**Notice of Decision  
Town and Country Planning Act 1990  
Town and Country Planning (Development  
Management Procedure) (England) Order 2015  
Approval of Permission for Development**

**Application No:** 6/2018/0008/HOUSE

**Development:** Replacement of existing windows and doors to rear of building.

**At Location:** 11 Fore Street Hatfield AL9 5AN

Title
**Existing & Proposed plan and
Elevations**

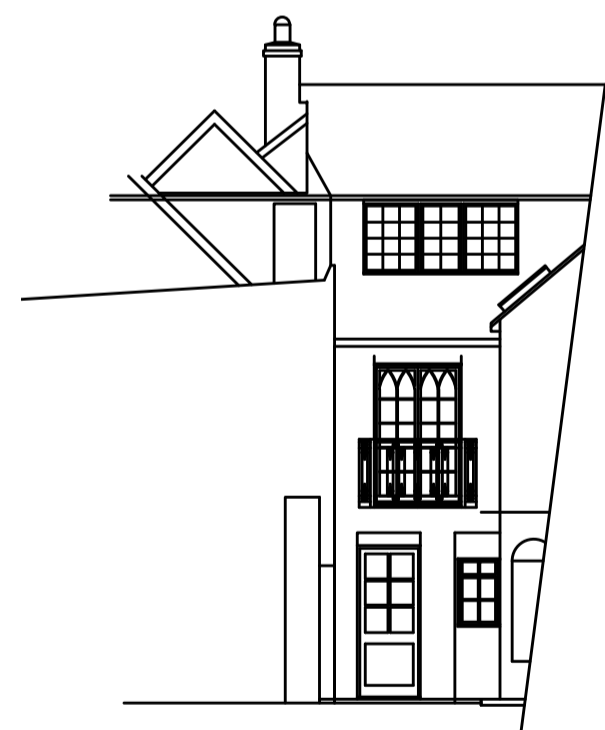
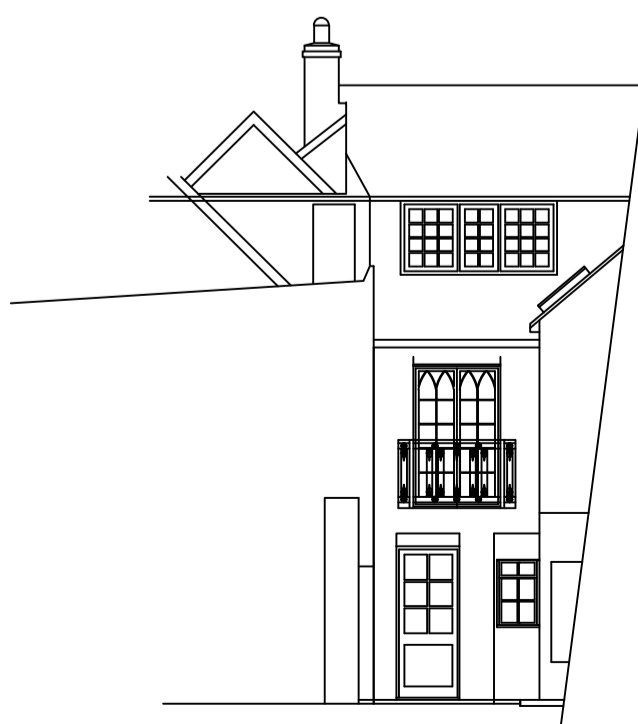
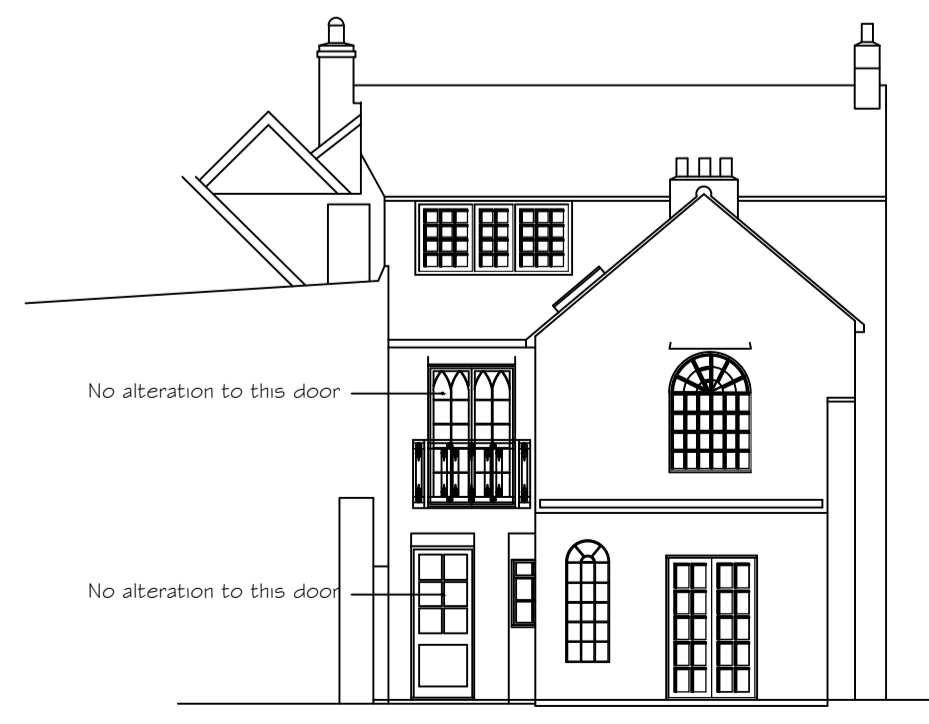
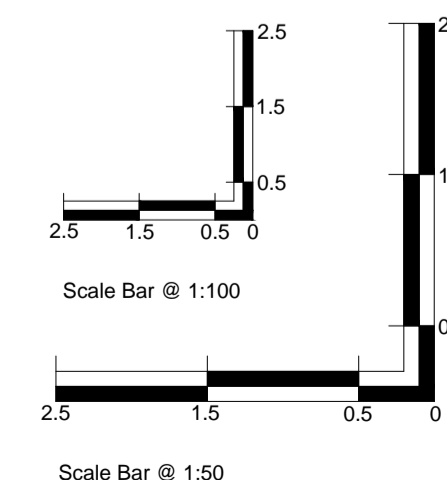
1. Notwithstanding the existing drawings, at the time of works, the new casement windows and new doors shall be in painted timber, slim-profile double glazed (max 14mm), flush meeting within the frames, with matching joinery for opening and fixed casements, and without trickle vents or surface mounted glazing bars and shall be permanently maintained as such.
